Subject: West I-40 Diversion Channel Utility Work at 64th Street, Hydrology at 64th Street. WCEA File: X02180027

We have reviewed the Hydrology at 64th Street and looked at the drainage reports concerning modifications to the cul-de-sac at the end of 64th street.

**TITLE: EL TESORO SUBDIVISION
 GRADING PLAN**

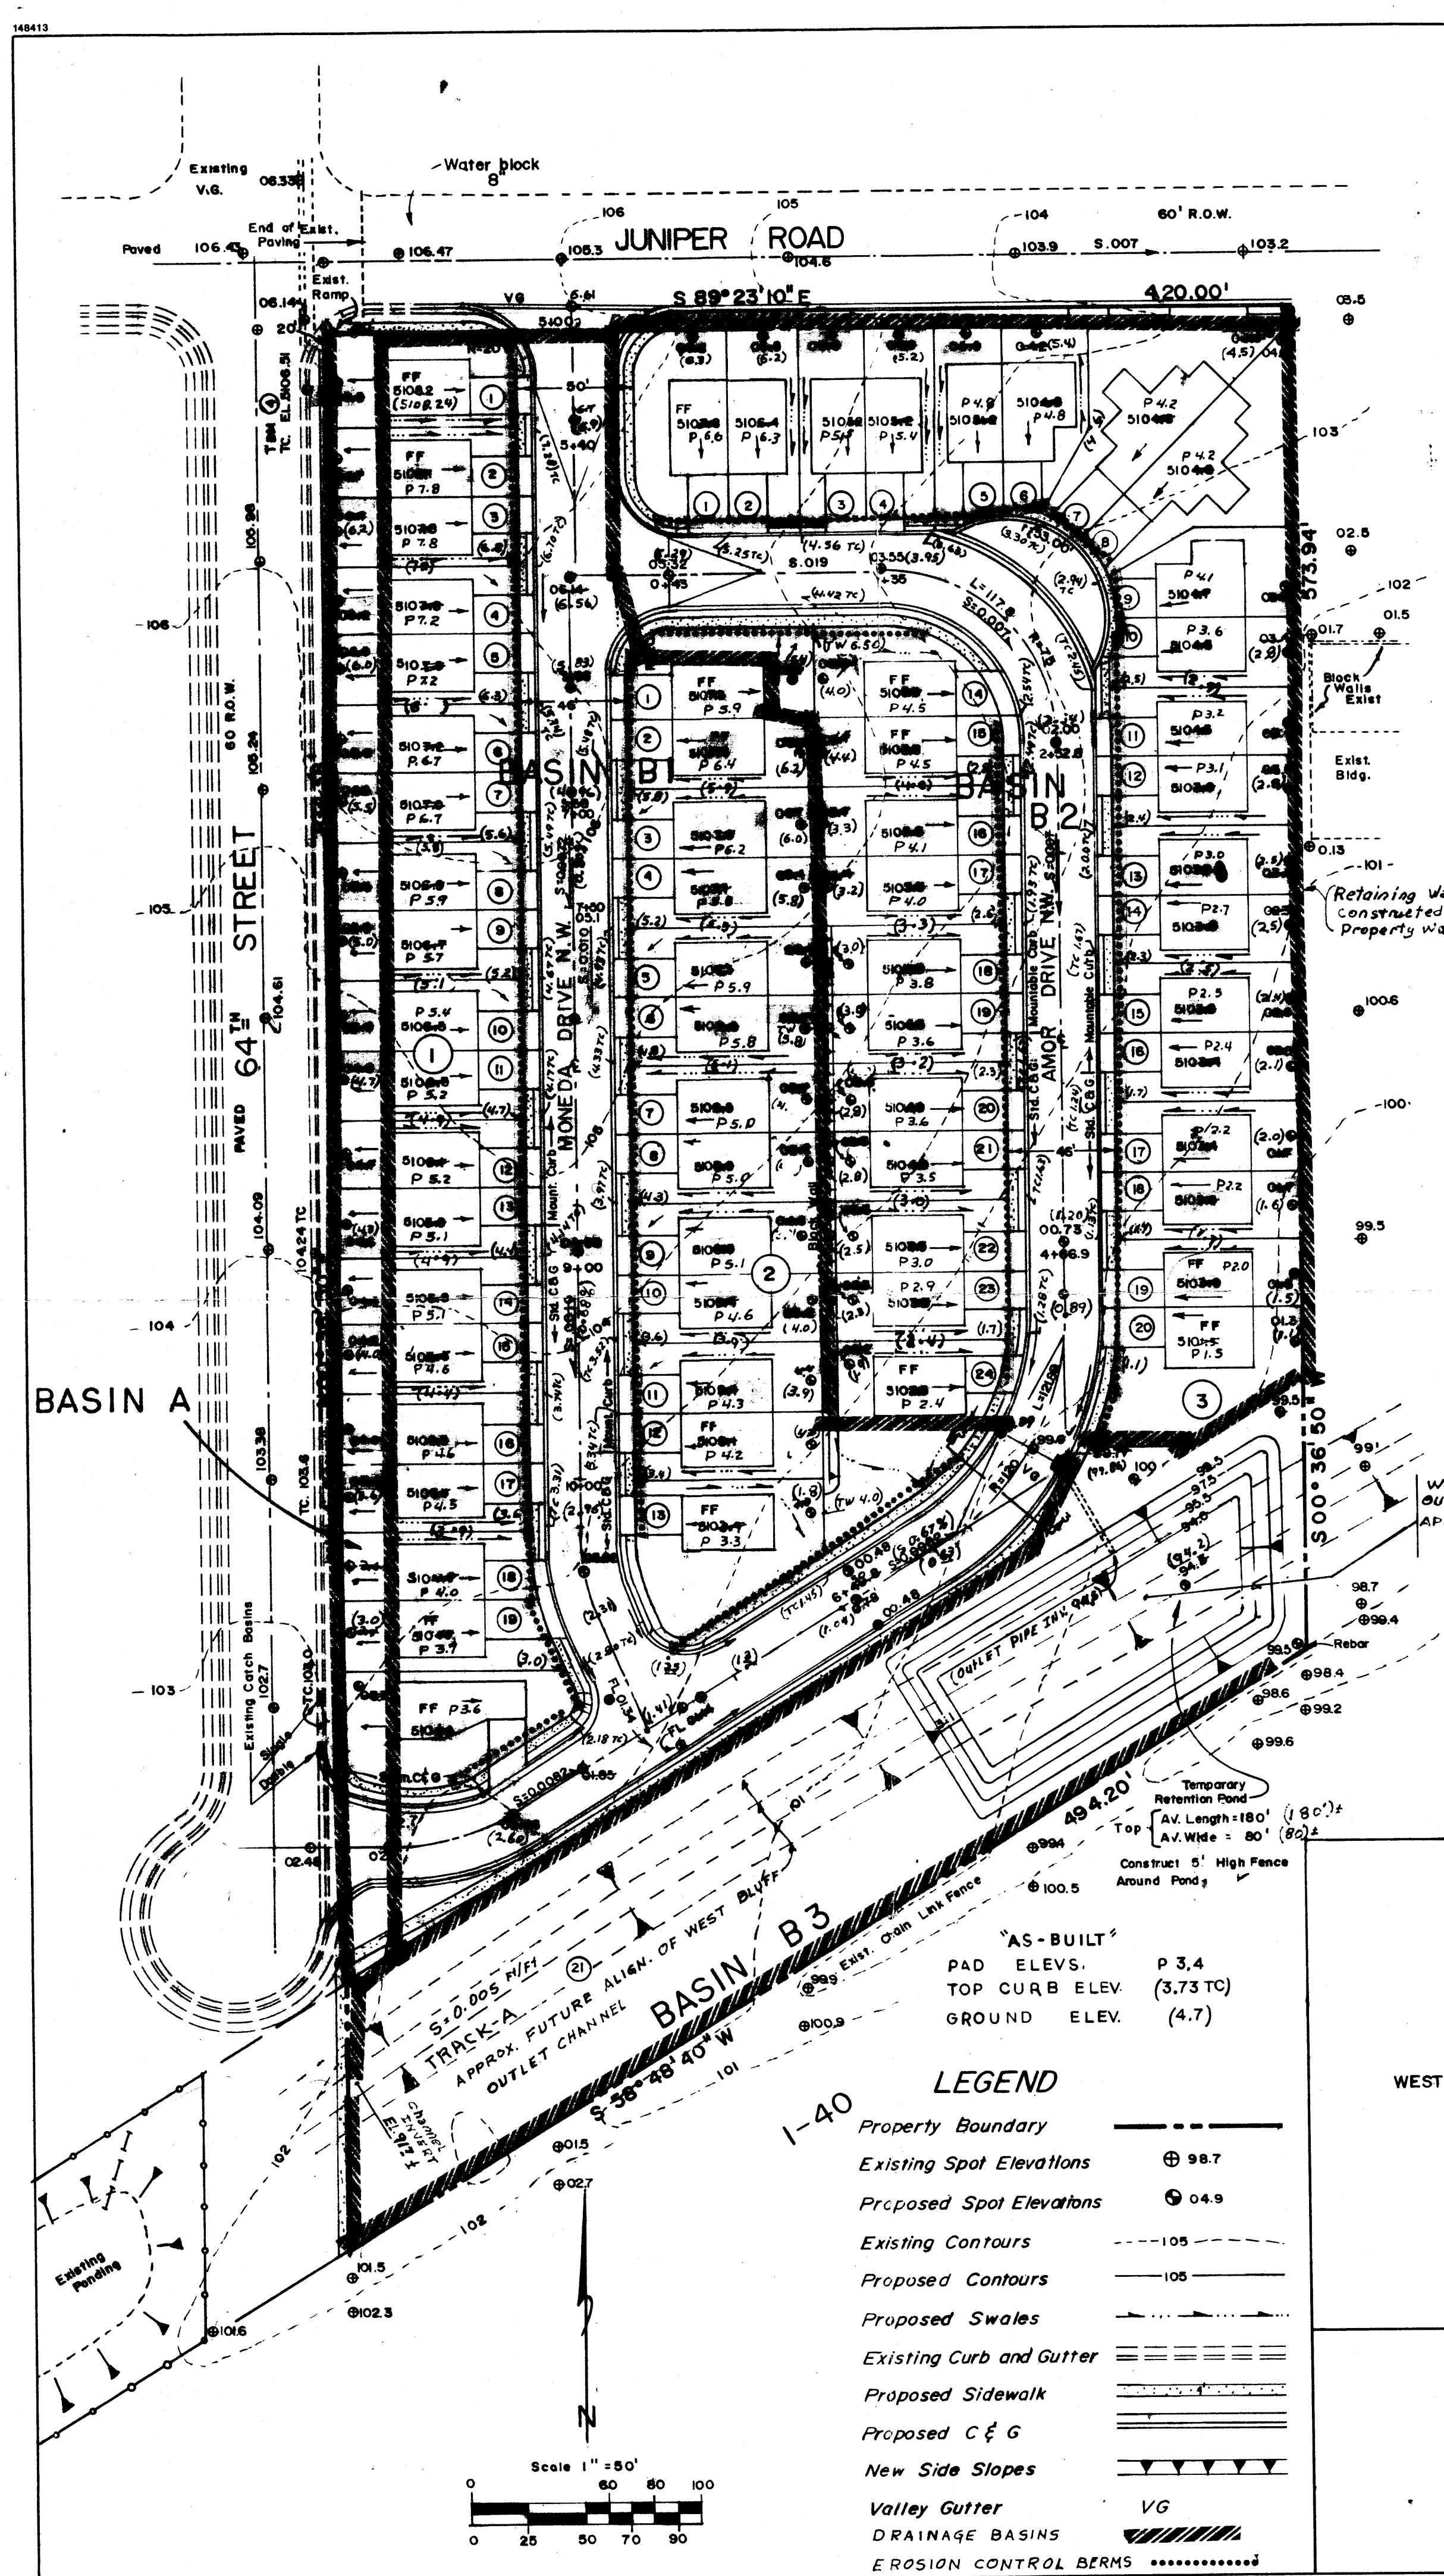
1. Submit an infrastructure list for review.
2. The outlet detail proposed does not meet City Standards and Storm Drain Maintenance requirements. The system should be either concrete channel with a minimum width of 10 feet or a storm drain with inlets, not a combination.

9. Be advised that the scale on this plan does not meet the requirements for rough grading the site. A scale of 1" = 20' should be submitted to provide the necessary detail to grade the site.
10. I cannot find the lots that are applicable to note 2.
11. How does your outlet tie in with the future West Bluff extension? I believe that there are preliminary channel grades available at this time. Scanlon and Associates is currently under design contract of this channel with the City.

TITLE: EL TESORO DRAINAGE PLAN

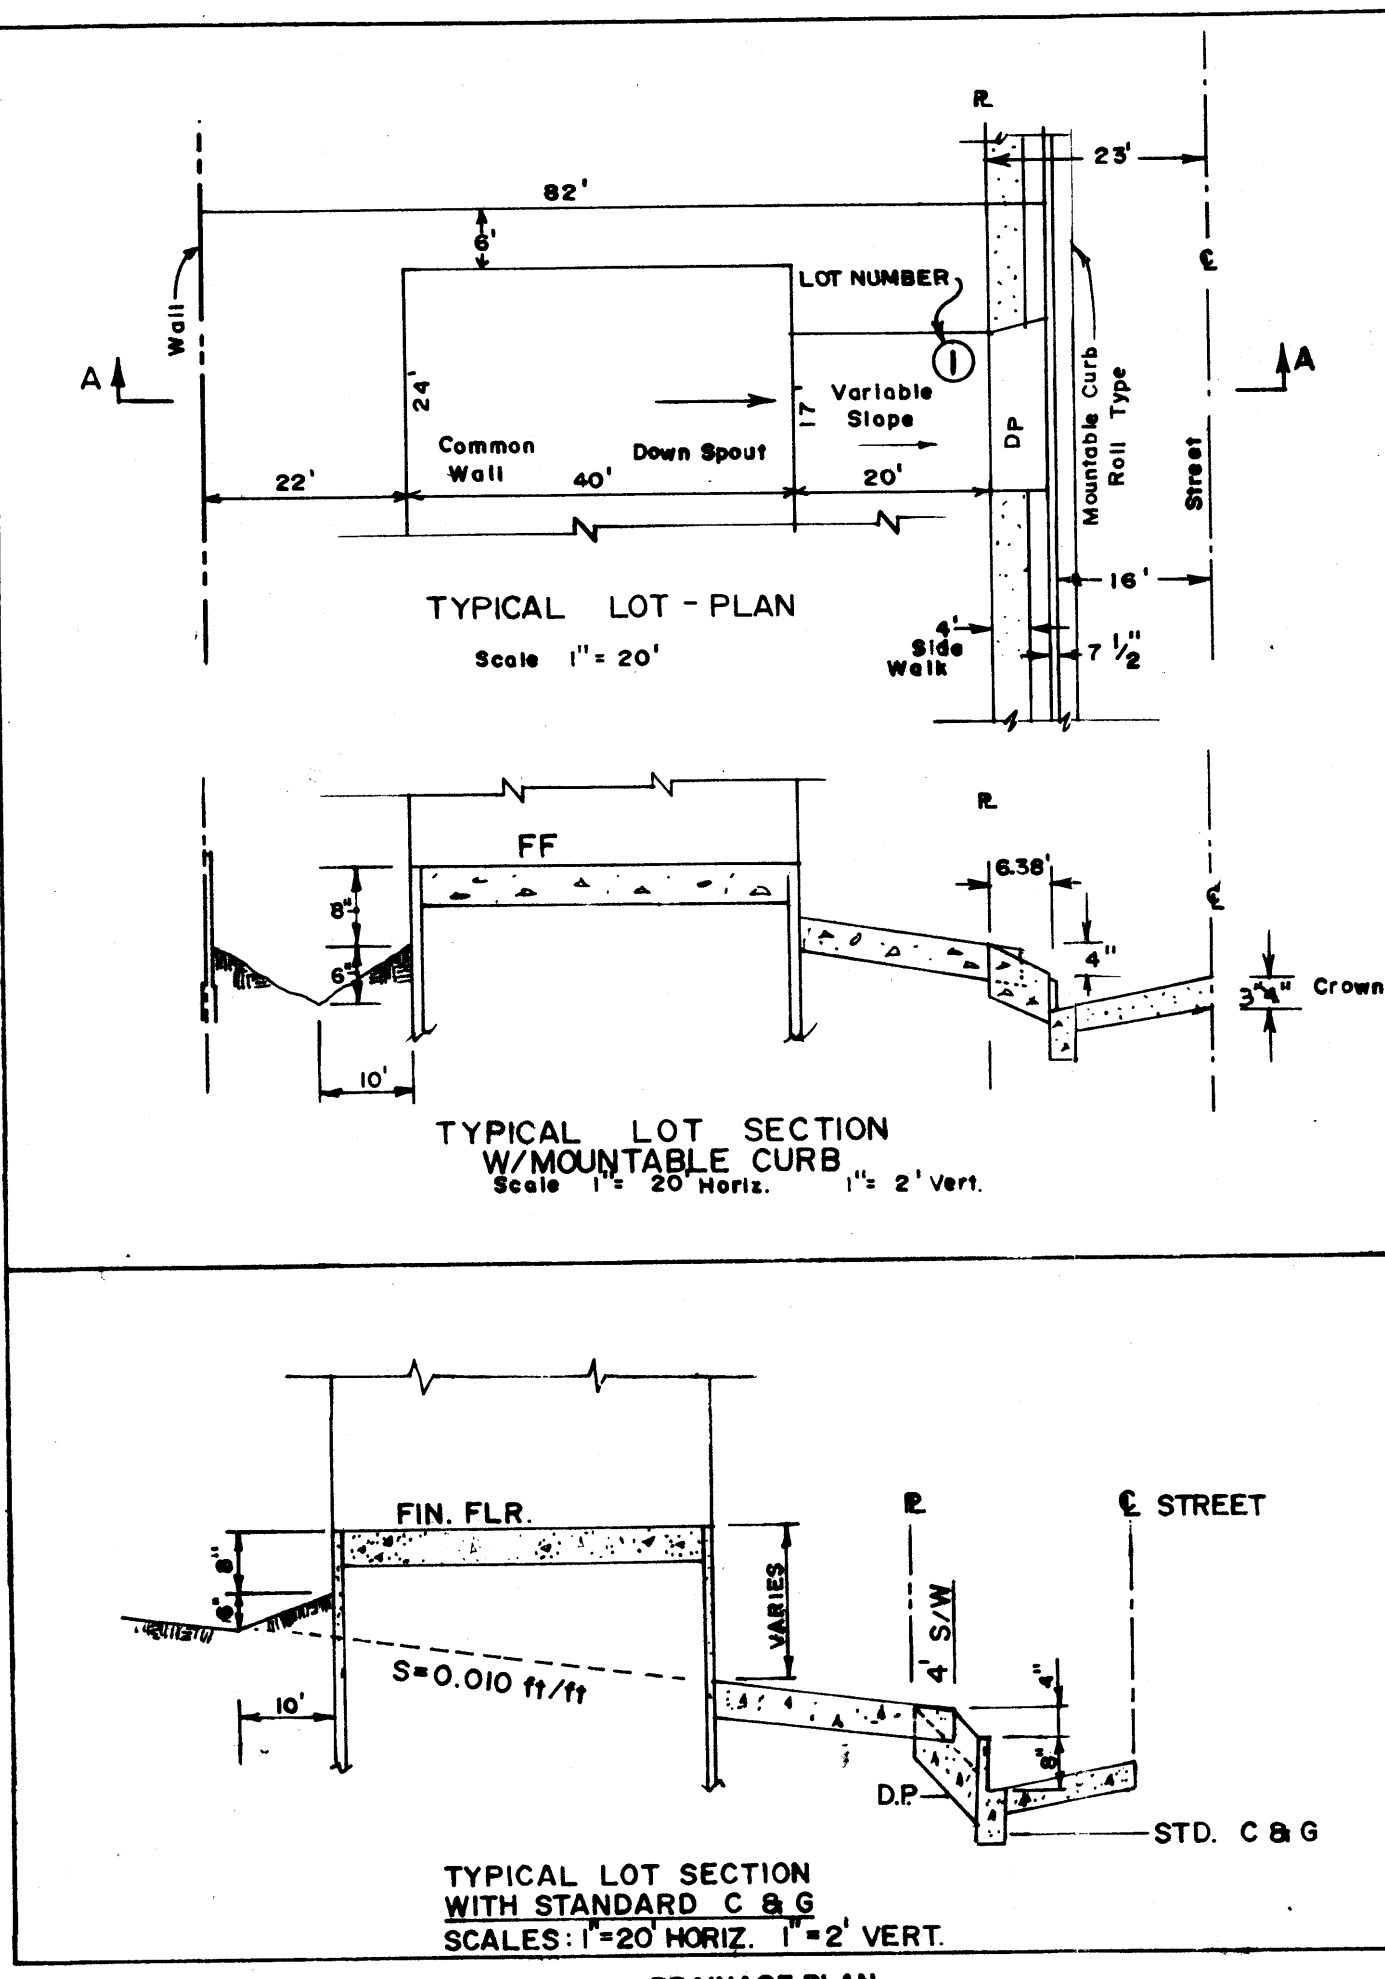
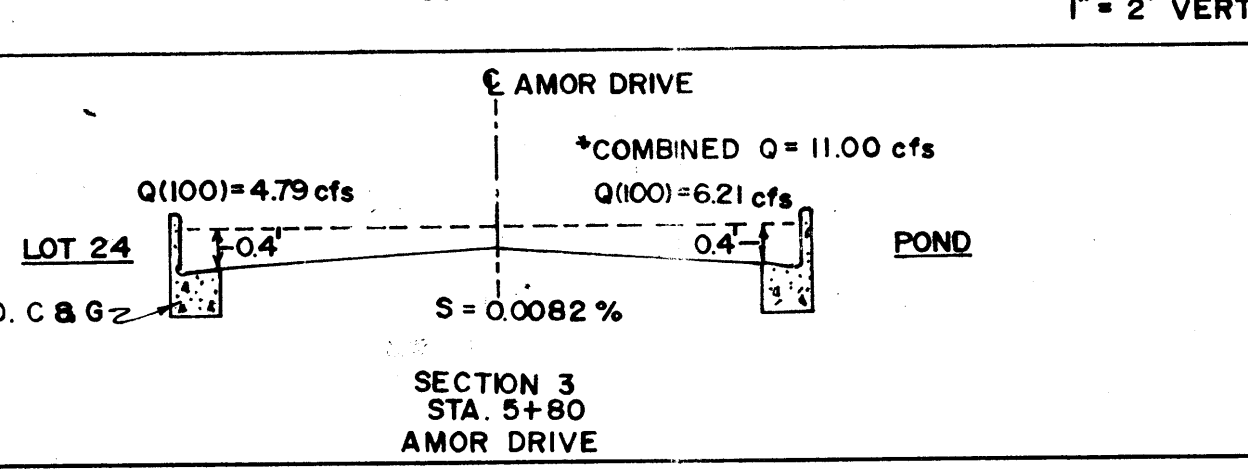
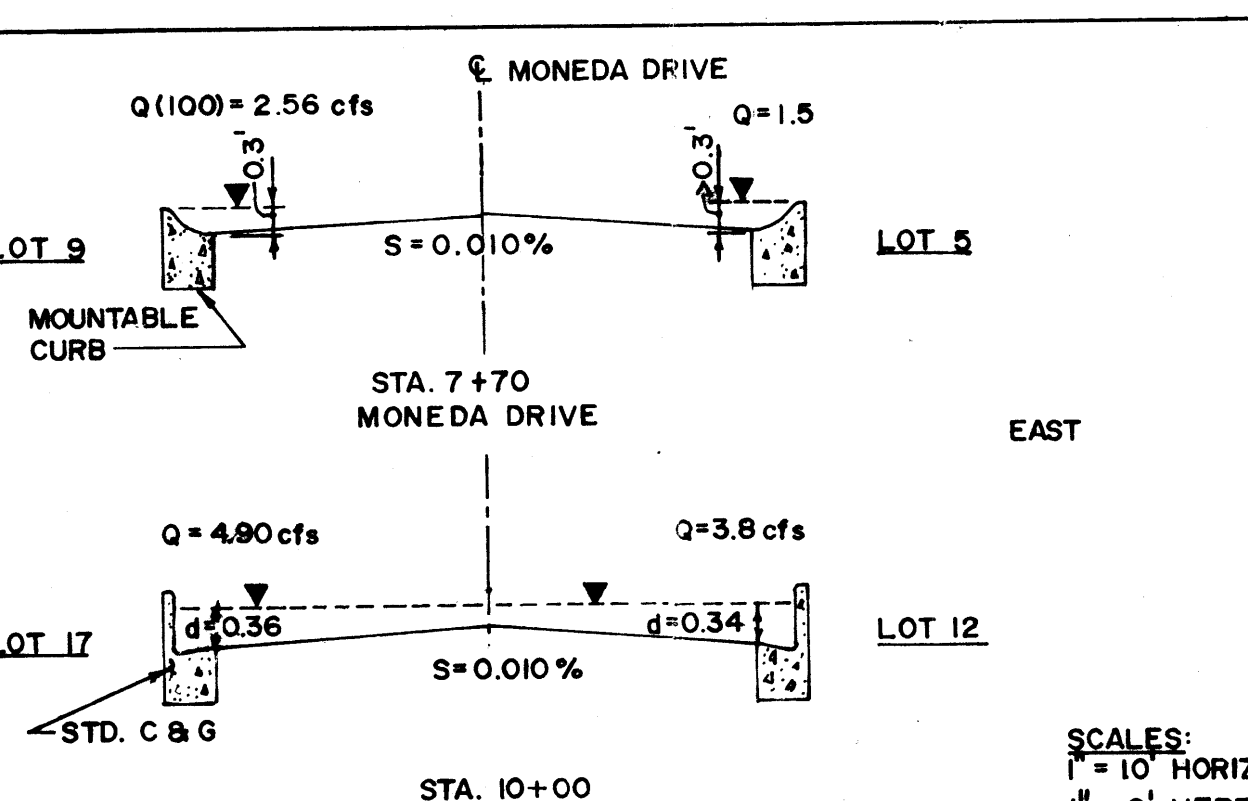
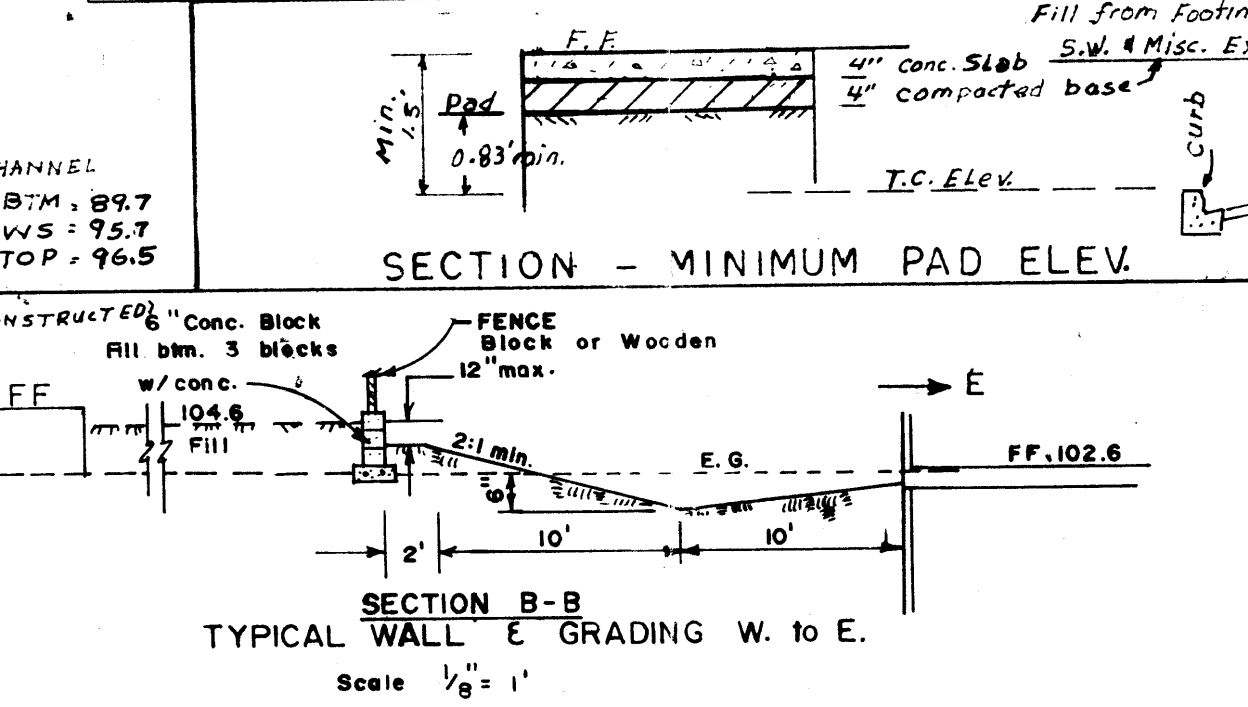
3. All street slopes should be set at a minimum of 0.50% in order to assure positive drainage.
4. The method used for calculating peak flow and volumes has been revised, there are now 4 treatment types. Either use the current version or use the rational method per the 1986 Emergency Rule. I don't know why but your flow rates and volumes seem low.

5. All side yard swales need to be set at a minimum of 1%.
6. Show the locations where your street hydraulics were taken. Be advised that if flows overtop the mountable curb then you need to go with Standard Curb and Gutter.

7. Show the drainage basin boundaries.
8. Show the existing capacity of the inlets and demonstrate if they can handle some of your flows.
